KITITAS COUNTY

MEMORANDUM

SUBJECT: Lonny Short Plat SP-21-00002

LONNY SHORT PLAT
PART OF SECTIONS 1 & 2, T. 19 N., R. 15 E., W.M.
KITTITAS COUNTY, WASHINGTON

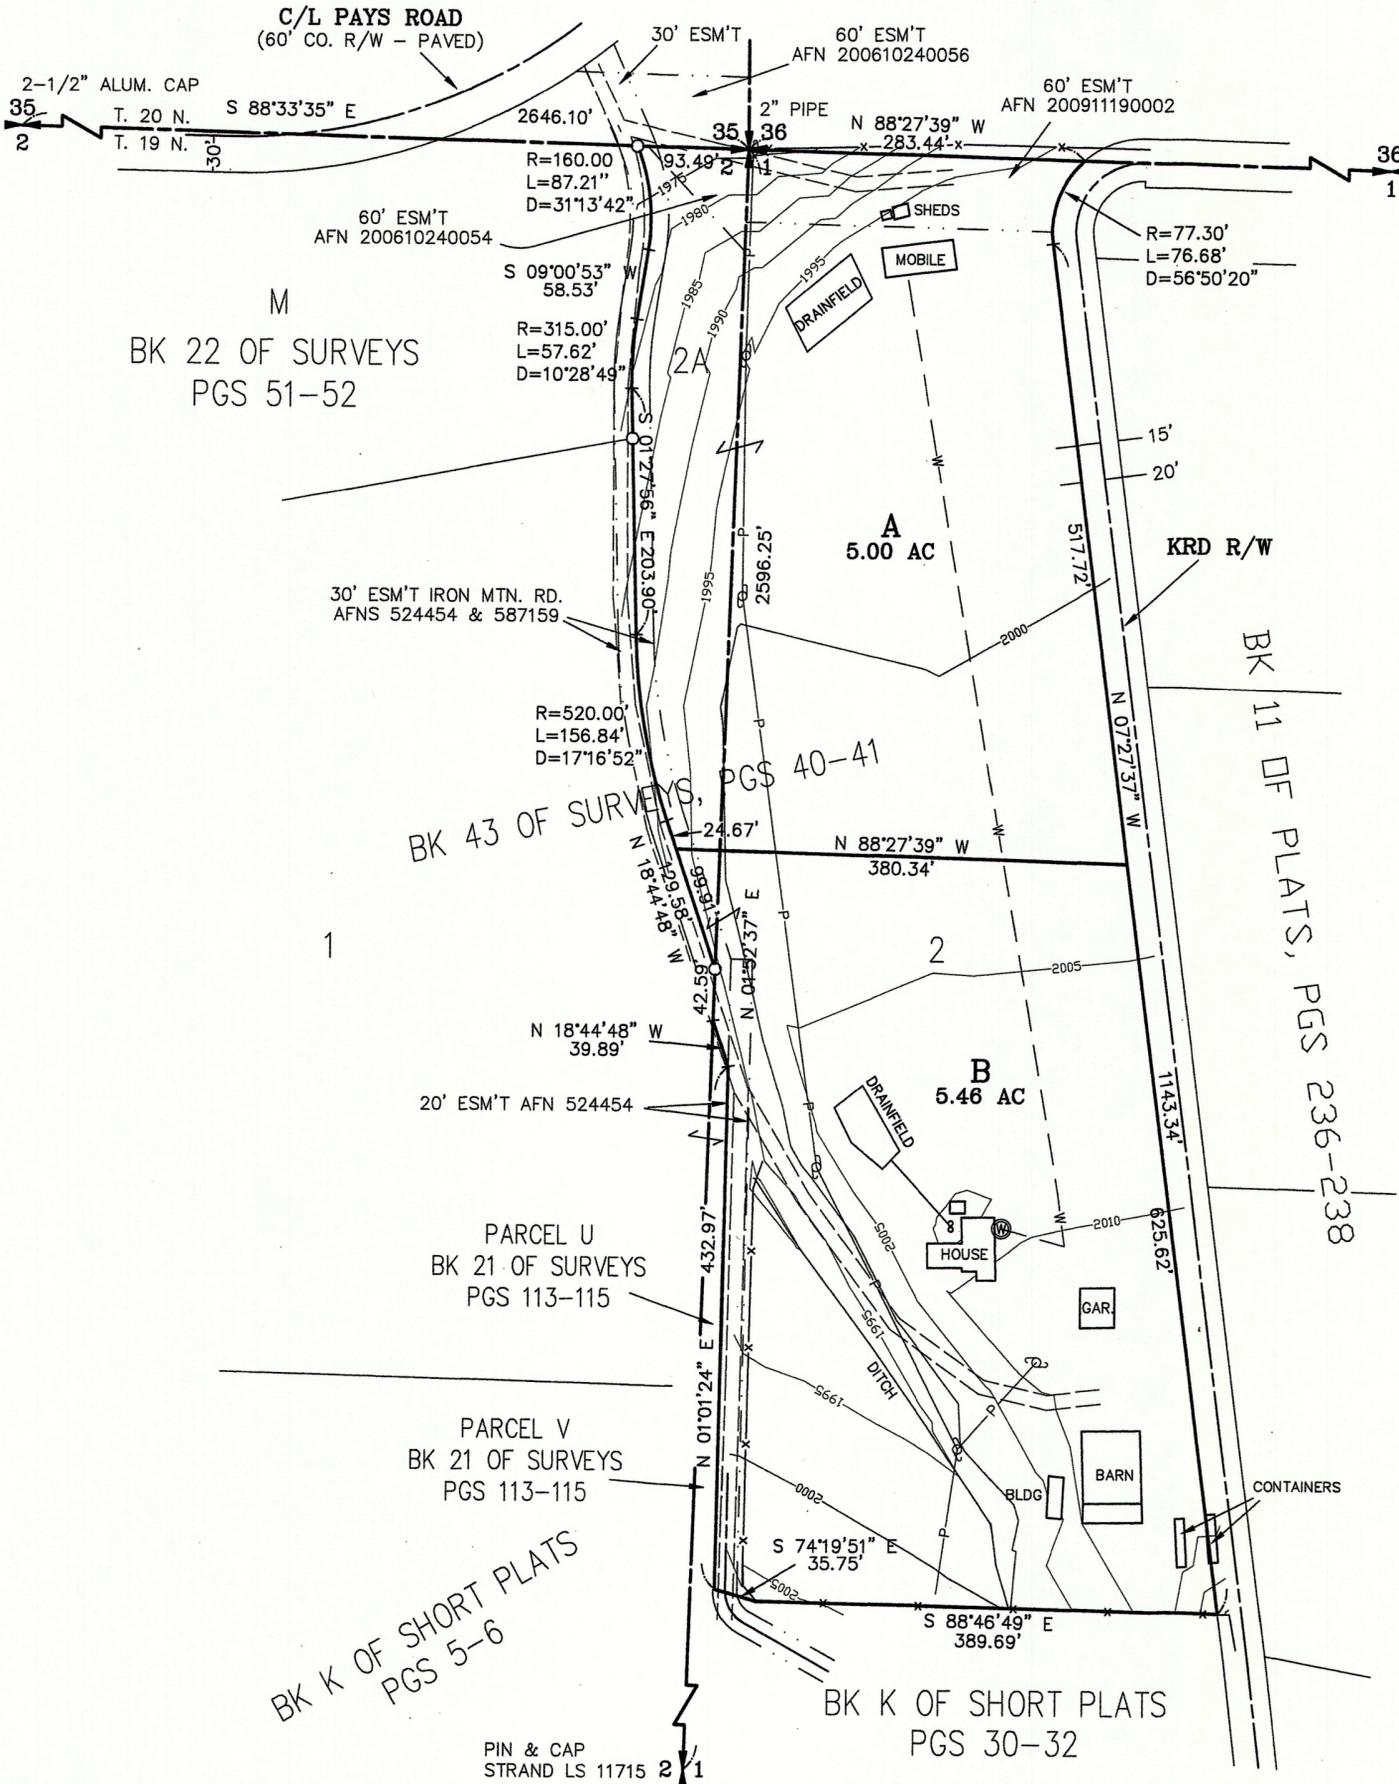
1. This Prelim Short Plat does not meet topo requirements as specified in WAC:332-130-145.
2. Overhead power and underground water lines are not shown within the legend.
3. A number of dimensions are obscured by crossing linework.
4. The position of easement 524454 in Parcel B, does not match survey 546065. This discrepancy should be noted.
5. Basis of bearing is not noted.
6. The Northernmost line of West boundary of Lot B does not match lot closures. (99.91 vs 104.91)
